Subject: RE: Planning Consultation on: BR/175/20/PL

Comments from Private Sector Housing:

Application No: BR/175/20/PL

Description of Works: Change of use from Student Accommodation to 3 no. dwellings, comprising 1 no. one bed apartment, 1 no. two bedroom house and 1 no. three bedroom house (resubmission of application BR/99/20/PL). This application may affect the setting of a listed building & affects the Upper Bognor Road & Mead Lane Conservation Area.

PROPOSED ELEVATIONS

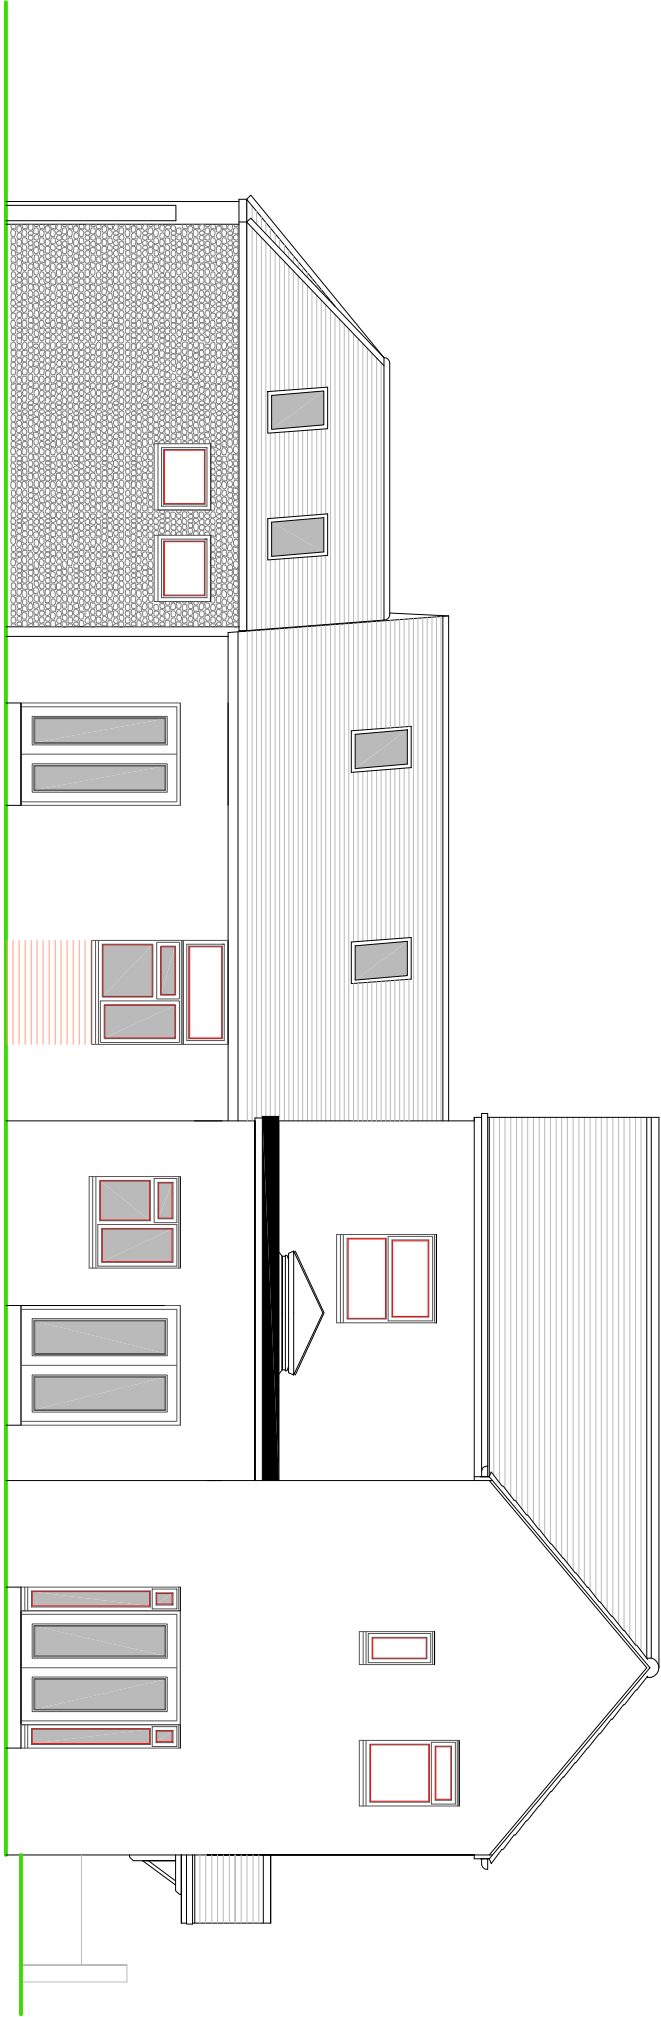
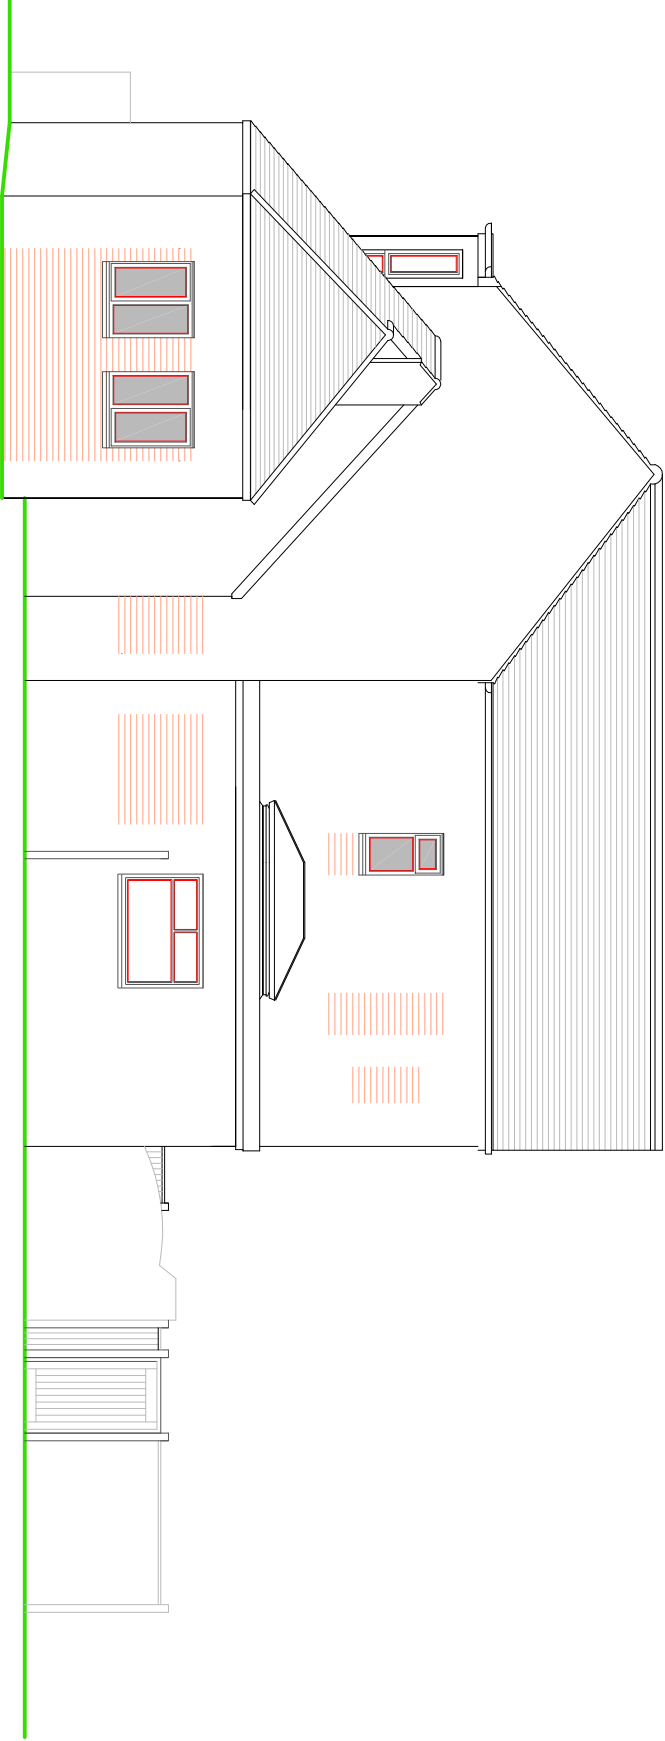
- The proposals for non-obscured windows, including an escape window in the bedroom of Unit 3 is acknowledged and is considered satisfactory.
The proposed escape window in the bedroom of unit 3 must have a sill height of not more than 1100mm from finished floor level, with an unobstructed openable area of 0.33m² and have a minimum 450mm height and 450mm width.
